From: Nick Laurence [REDACTED]
Sent: Friday, August 10, 2018 8:01 AM
To: Sue Newman
Cc: Stephen Brooker
Subject: Proposed Ashley House scheme.

Subject: FW: Ashley House

Subject: Ashley House

CLIENT 120 Aldwick Rd LLP
PROJECT Ashley House - West Wing
DRAWING TITLE Proposed Ground Floor Plan

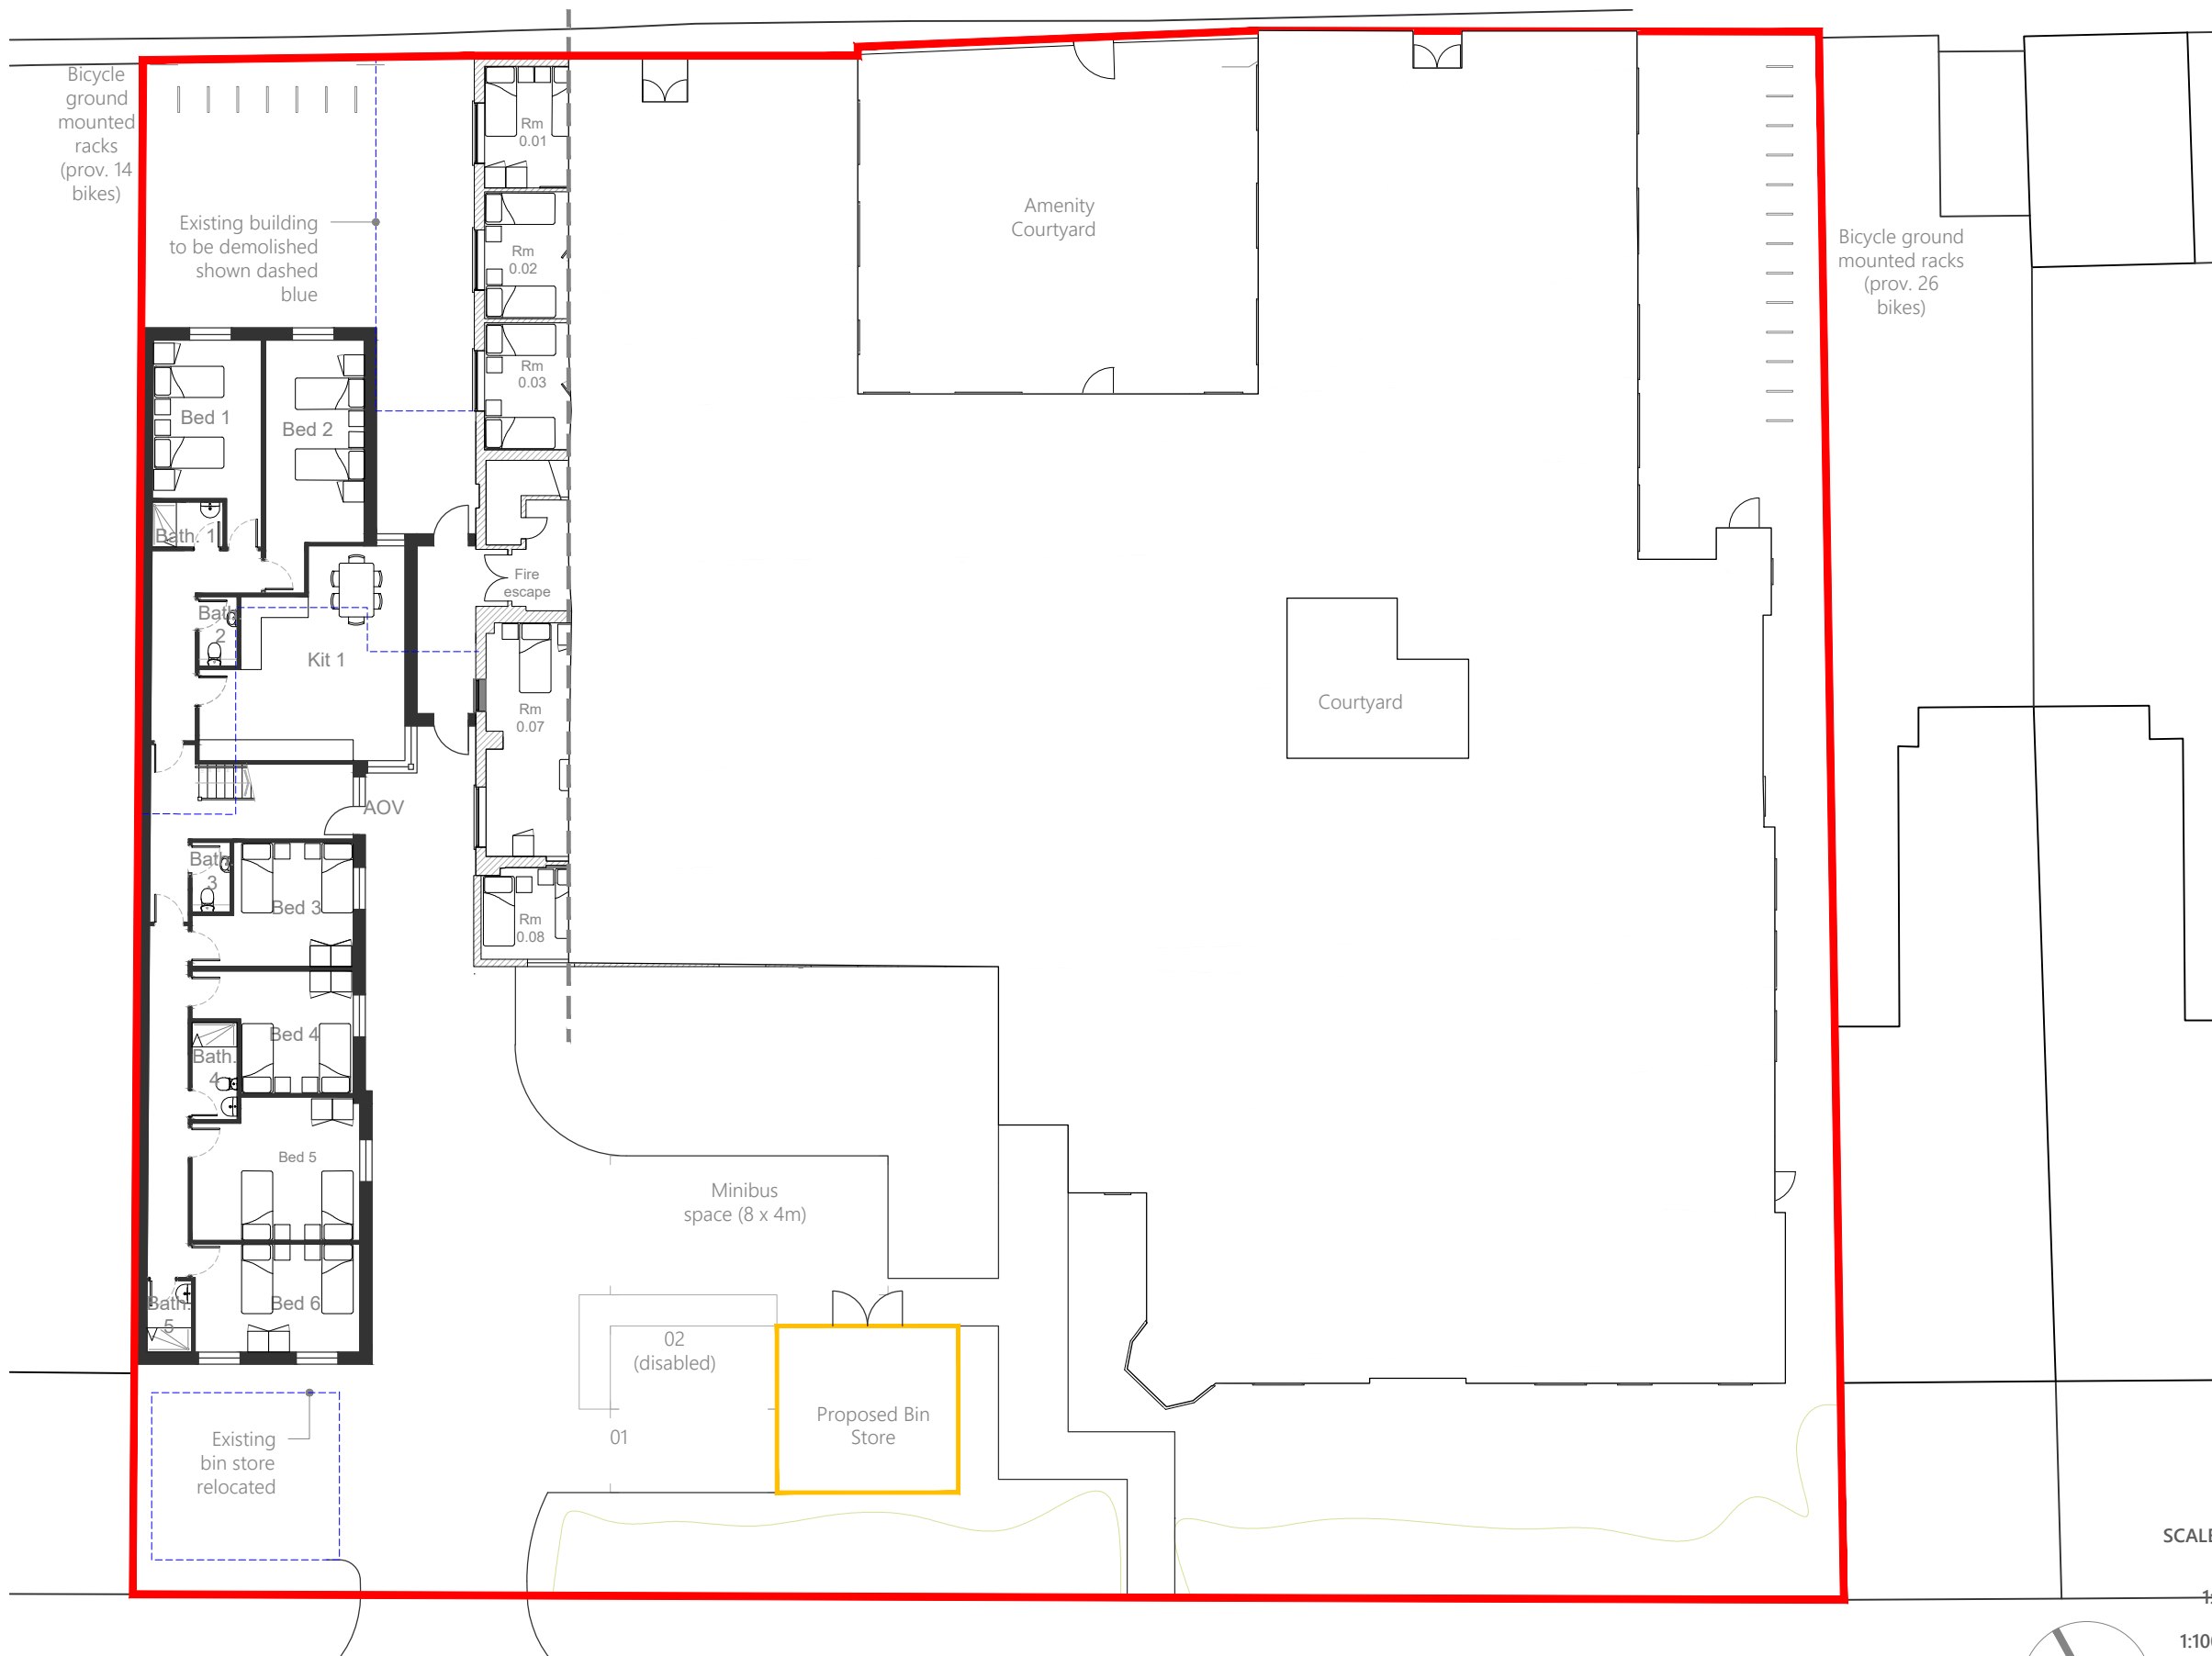
We have looked at your request to have a meaningful 800mm gap between our new proposed building and your existing. Unfortunately the scheme is unviable with a gap of this size.

Thank you for asking your architect to phone me. He told me in that call that the scheme would not work if there was a reasonable gap of 800mil, I have informed him that I am unconcerned at what you build on the proviso that your design statement allows for a gap for maintenance between the 2 properties. I also voiced my concern about not being informed of a public consultation, being led to believe that you were only going to ADC to discuss your planning. Is there anyway you could design something we would both be happy with?

As we have discussed we are proposing a new wall adjoining the boundary, which will sit independently of the existing wall. We appreciate this is not what you were after and we will ensure this is mentioned specifically in our planning statement.
